Proposal: 13-15 & 17 Oxford Street & 2 Verona Street, Paddington – SSD-87245208

In response to the comments received on 5 May 2026 regarding Stormwater Management and Public Domain from the City of Sydney, we are pleased to provide you with our response below:

Drawing Title <b>STORMWATER CONCEPT PLAN LEVEL 1</b>			
Scale 1:200	Project No. 25080	Dwg. No. 107	Issue B

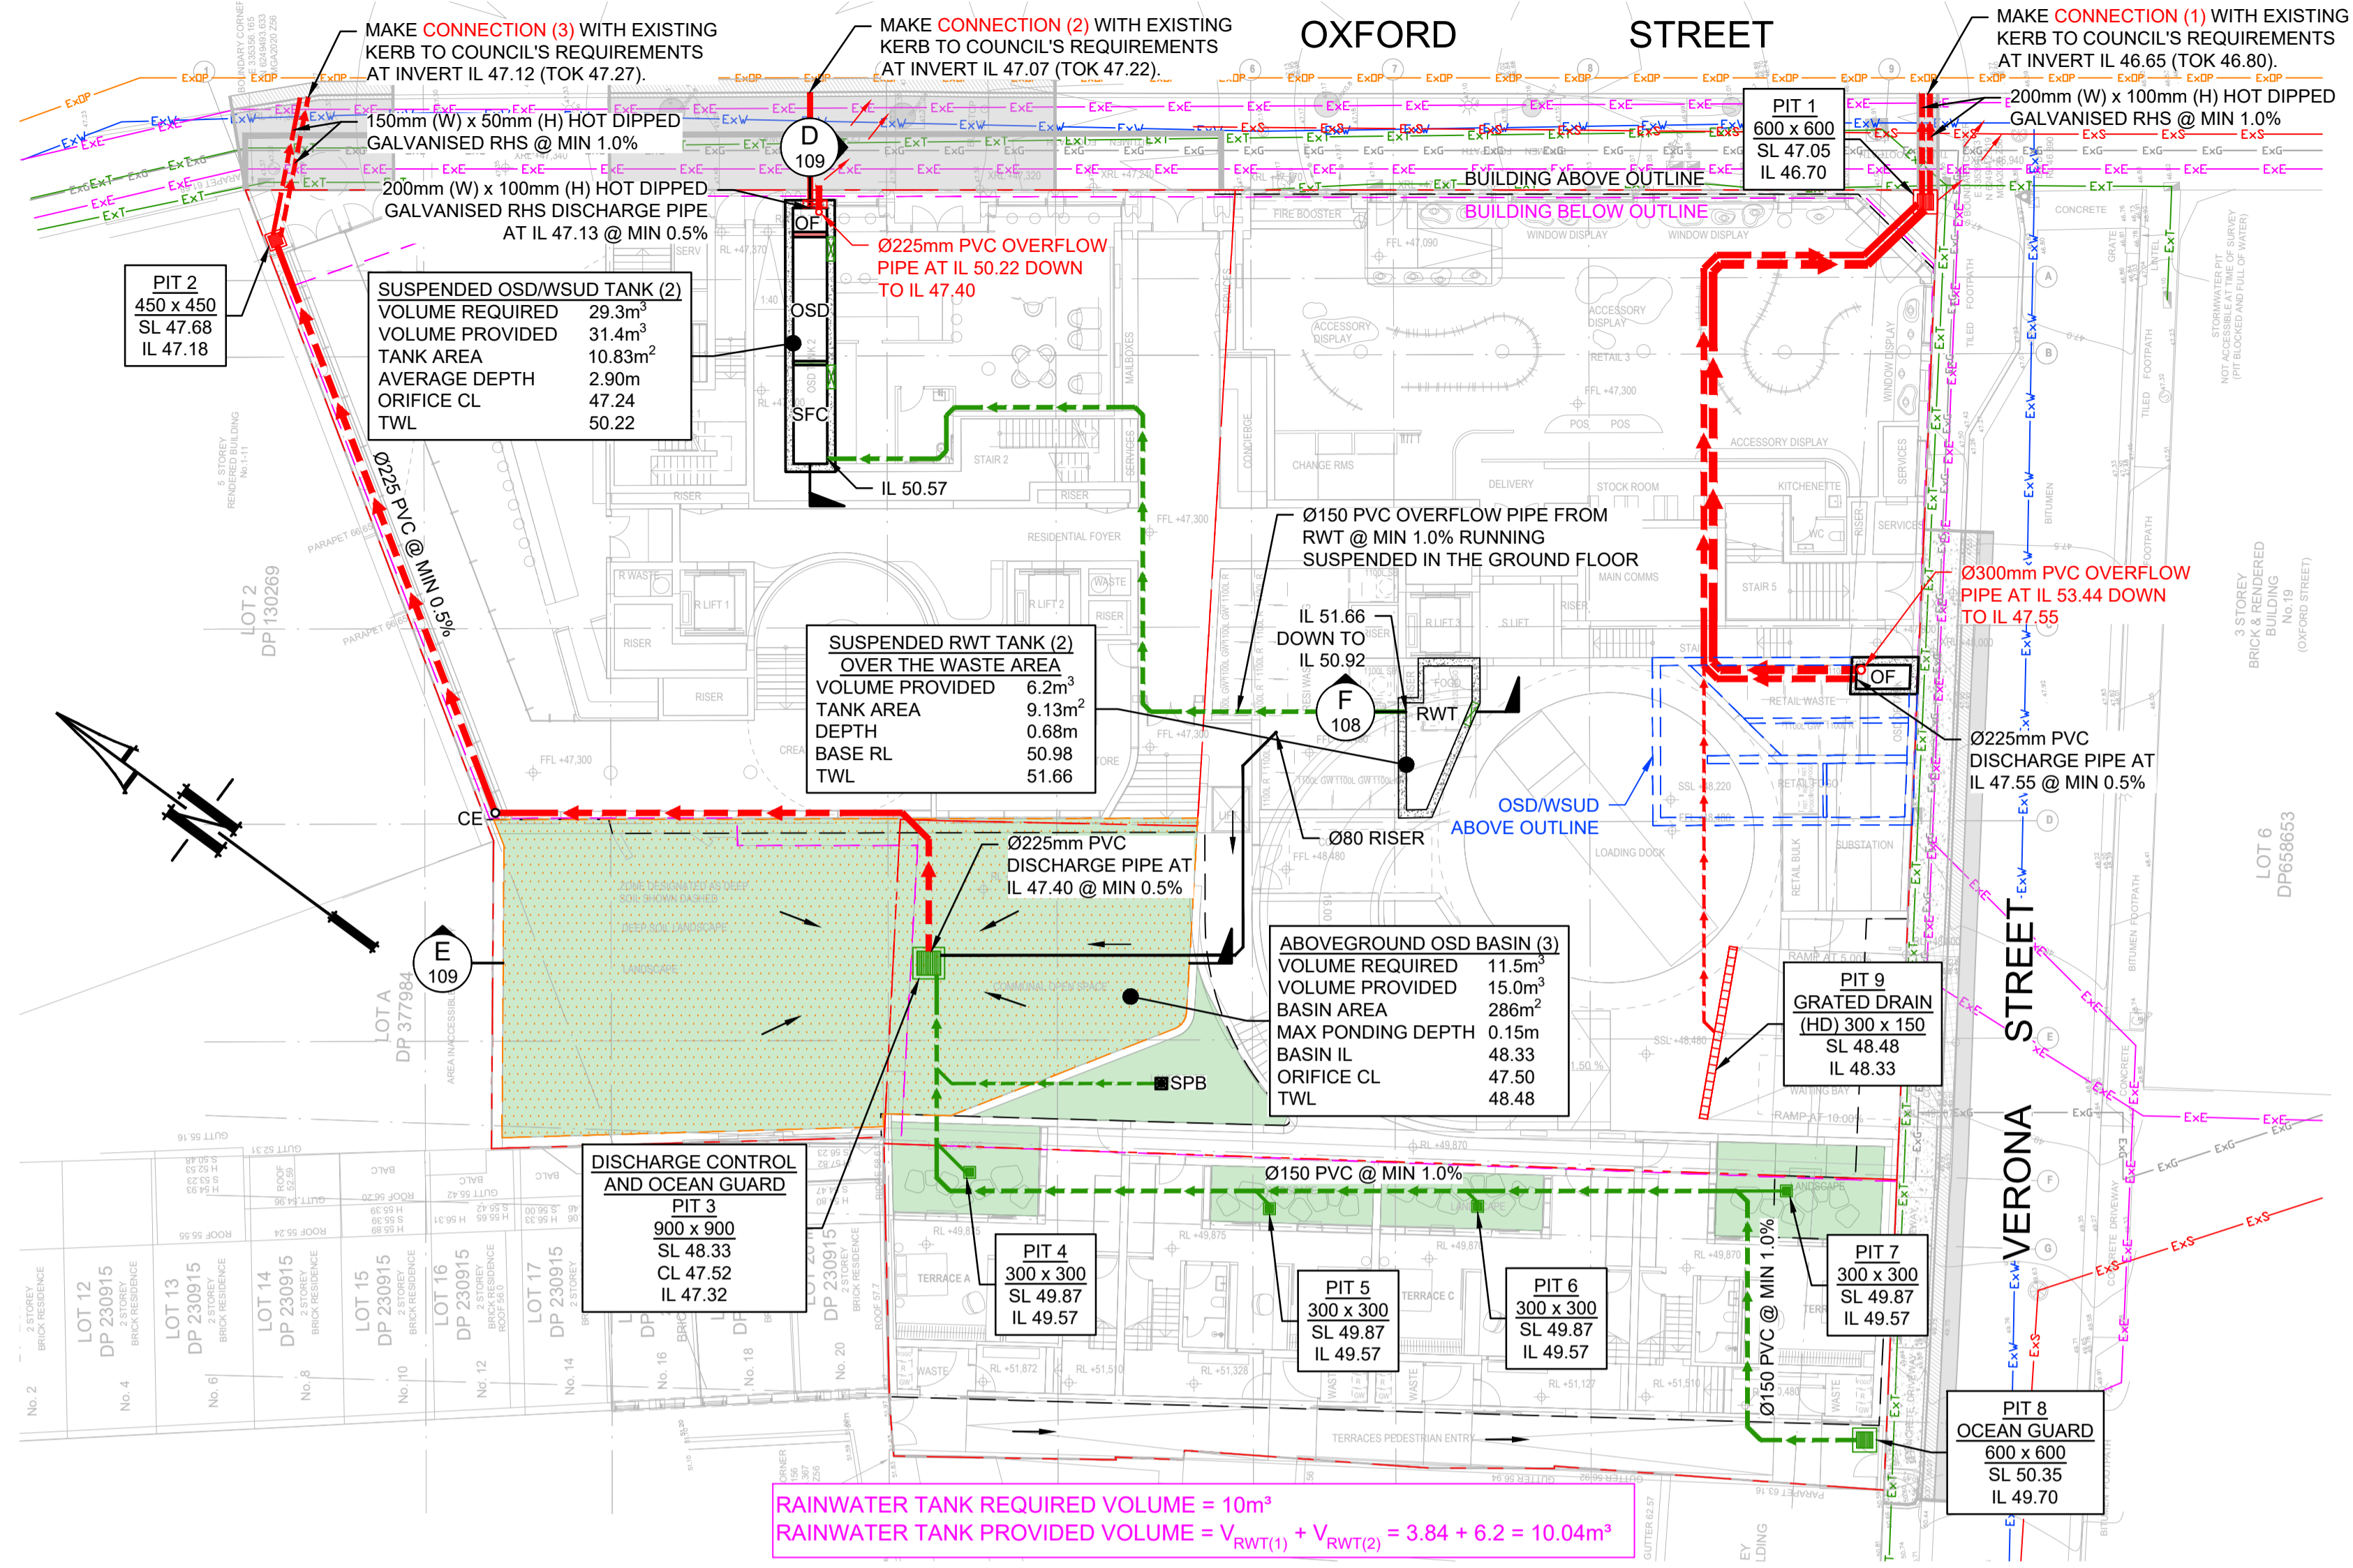
Comment	Consultant Response
<p><u>10.1 Stormwater drainage</u> The emergency overflow grate of OSD No. 1 and No. 2 is proposed to be located at level 1, which is not acceptable. The drainage arrangement must be revisited so that overflow is directed in a controlled manner from both OSDs, rather than freely discharging from the Level 1 elevation to the footpath. Connections to the kerb & gutter must be via RHS per the City's specifications and standard drawing Kerb Stormwater Outlets 1.1.14.</p>	<p>The drainage design is revised to ensure that emergency overflow from both OSDs is directed in a controlled manner to a lawful point of discharge. Alternative arrangements are incorporated so that overflow is managed hydraulically and complies with council requirements, rather than discharging freely from the Level 1 elevation. The connections to the kerb & gutter are revised to comply with the City's specifications. All outlets are detailed as RHS connections in accordance with Standard Drawing Kerb Stormwater Outlets 1.1.14. Please refer to the updated stormwater plans prepared by Telford Consulting, dated 22/05/2026, for full details of the amended design.</p>

Drawing Title			
<b>WSUD CATCHMENT PLAN AND MUSIC RESULTS</b>			
Scale	A1	Project No.	Dwg. No.
As Shown	25080	110	D

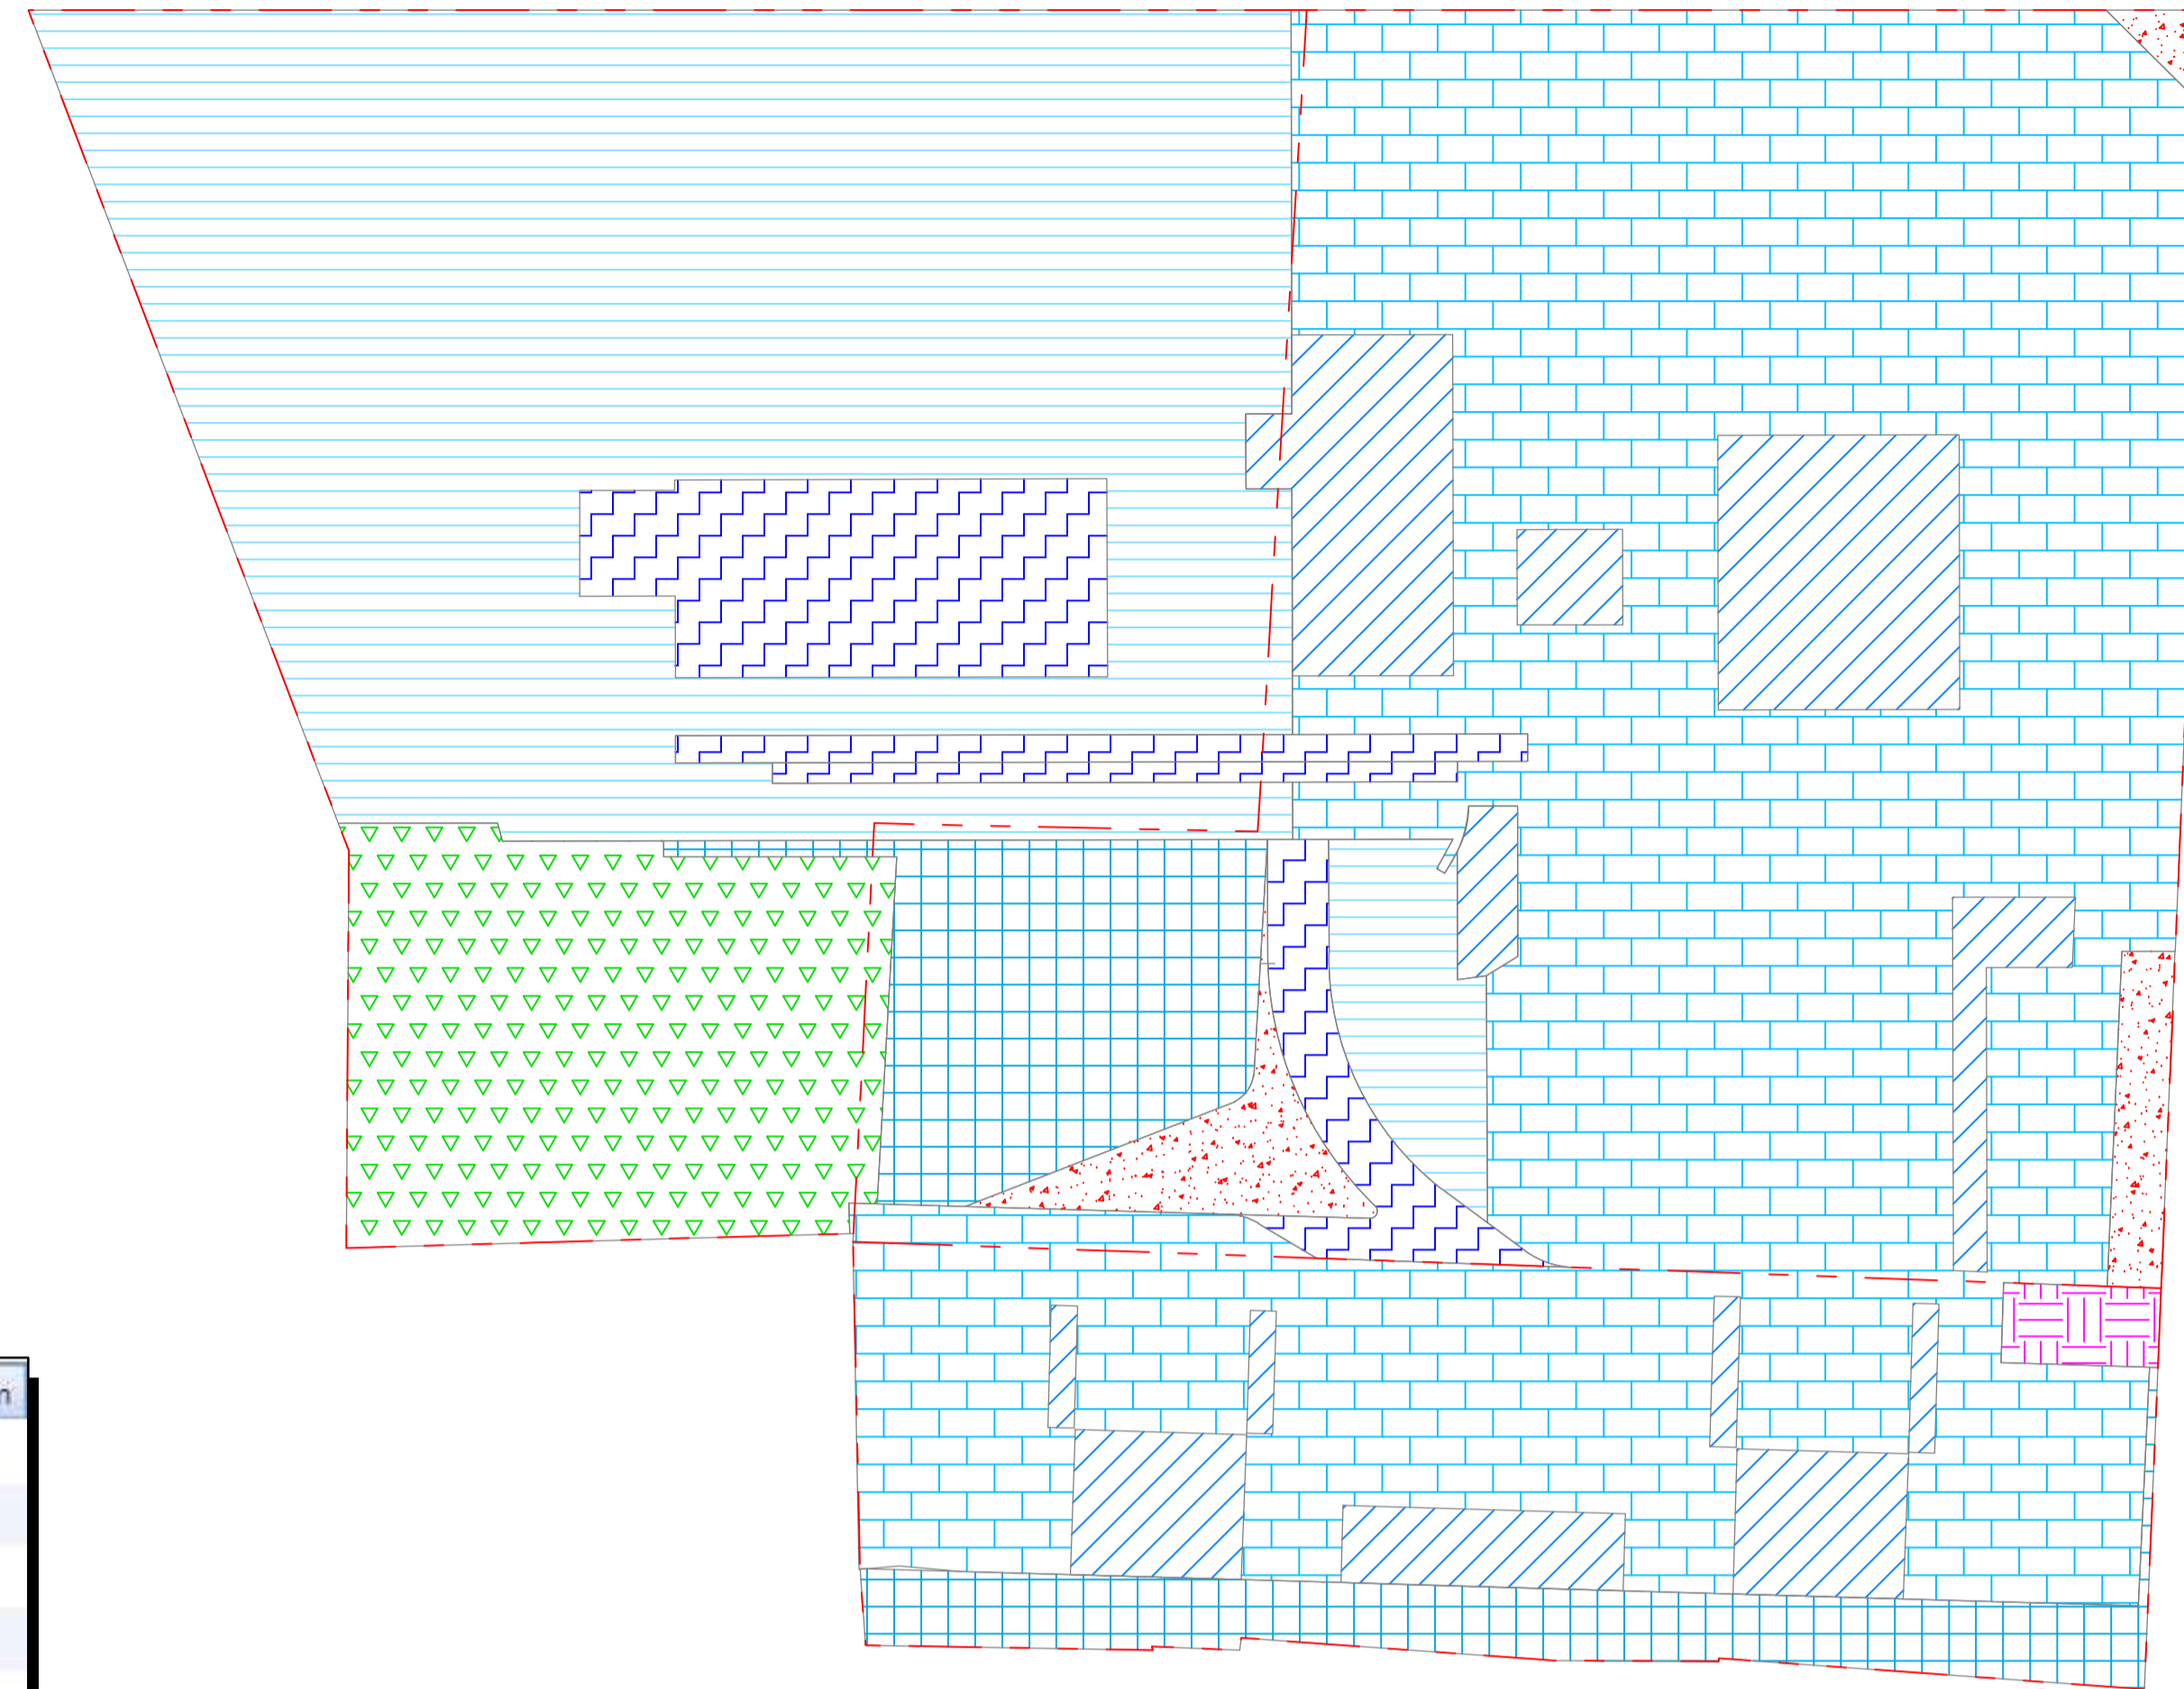
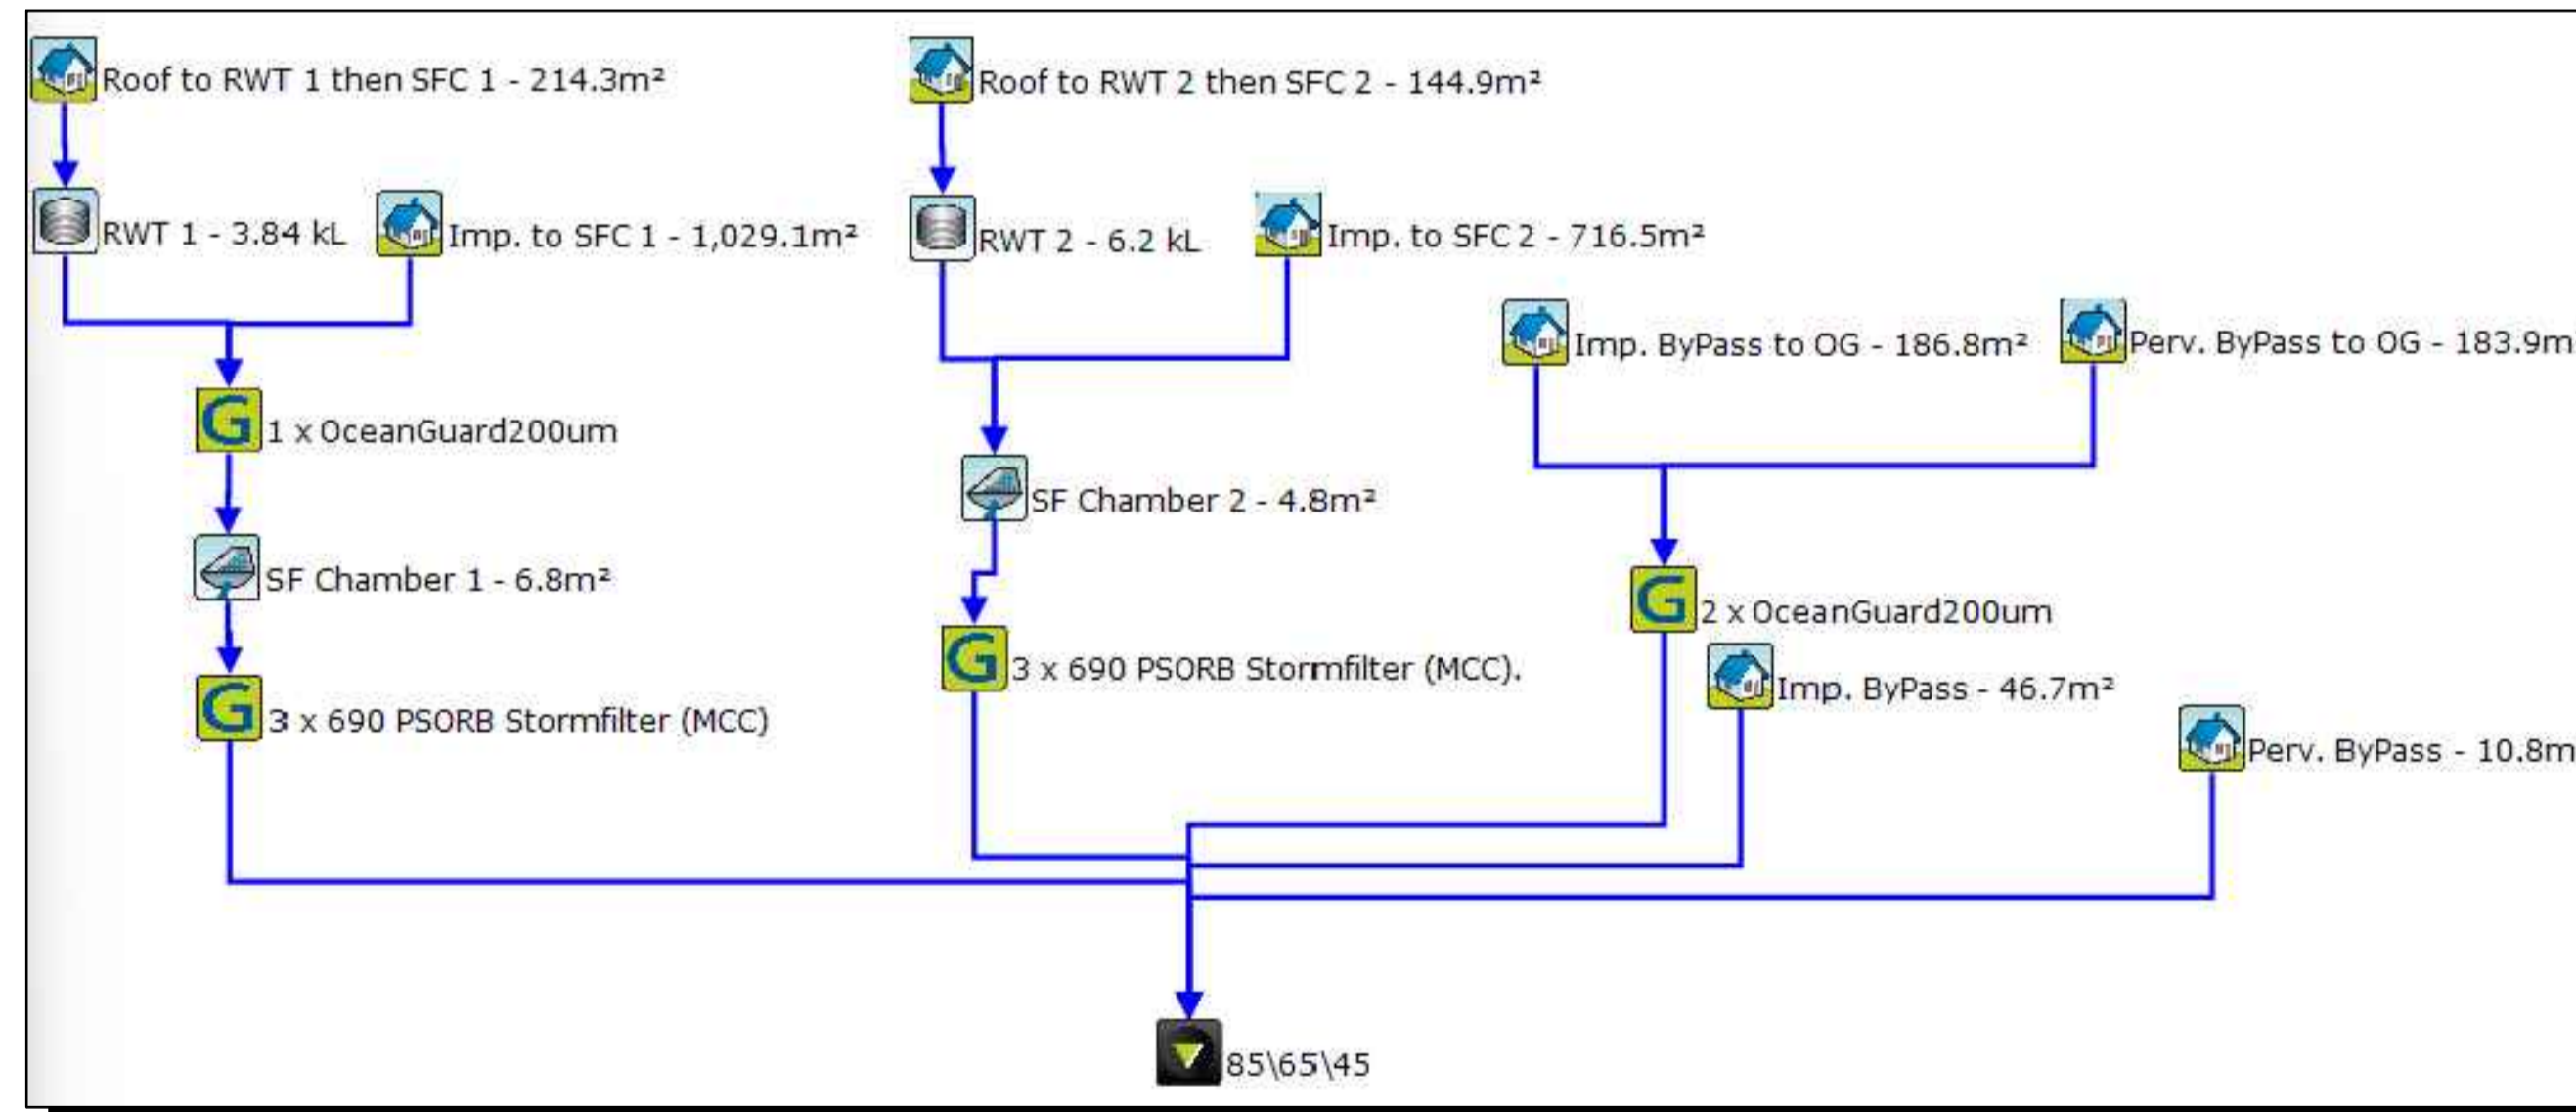
<p><u>10.2 Stormwater Quality</u> The proposed Music Link report is required to be updated to provide the following:</p> <ul style="list-style-type: none"> i. Soil type ii. The SF Chamber(s) is required to have failing parameters for all pollutants (i.e. Nitrogen, Phosphorus, etc) and should not be contributing to the removal of the pollutant load. 	<p>The MUSIC Link report is updated to incorporate the required soil type information. In addition, the SF Chamber(s) are amended to reflect failing parameters for all pollutants, ensuring that the chamber is not contributing to pollutant load reduction. Please refer to the appendix D in the Integrated Water management plan TEL25080.SW.IWMP - 13-15 & 17 Oxford St & 2 Verona St, Paddington prepared by Telford Consulting, dated 22/05/2026.</p>
<p><u>11.1 Levels</u> The following outstanding level information is required to be provided prior to determination:</p> <ul style="list-style-type: none"> i. The updated architectural plans should be incorporated into the revised civil works layout plan, with the proposed driveway width clearly indicated. ii. Longitudinal sections through the driveway crossing are required to indicate adequate headroom clearance (4m) for the largest vehicle permitted to access the site (10.6m waste vehicle), in accordance with AS/NZS 2890.2. iii. Longitudinal sections must also include sections through the centreline of each entry at the boundaries and must demonstrate compliance with the required footpath 	<ul style="list-style-type: none"> i. The architectural plans are incorporated into the revised civil plans showing clearly the driveway width. Please refer to TEL25080.CIV.DA - 13-15 & 17 Oxford Street & 2 Verona Street, Paddington [C] sheet C101. ii. Waste trucks will not access the basement as all waste collection will be done at the ground floor in the loading dock. Accordingly, no need for the ramps to have 4m headroom clearance. iii. Sections through the centreline of each entry have been included on the longitudinal section. Please refer to TEL25080.CIV.DA - 13-15 & 17 Oxford Street & 2 Verona Street, Paddington [C] sheets C301 & C302.
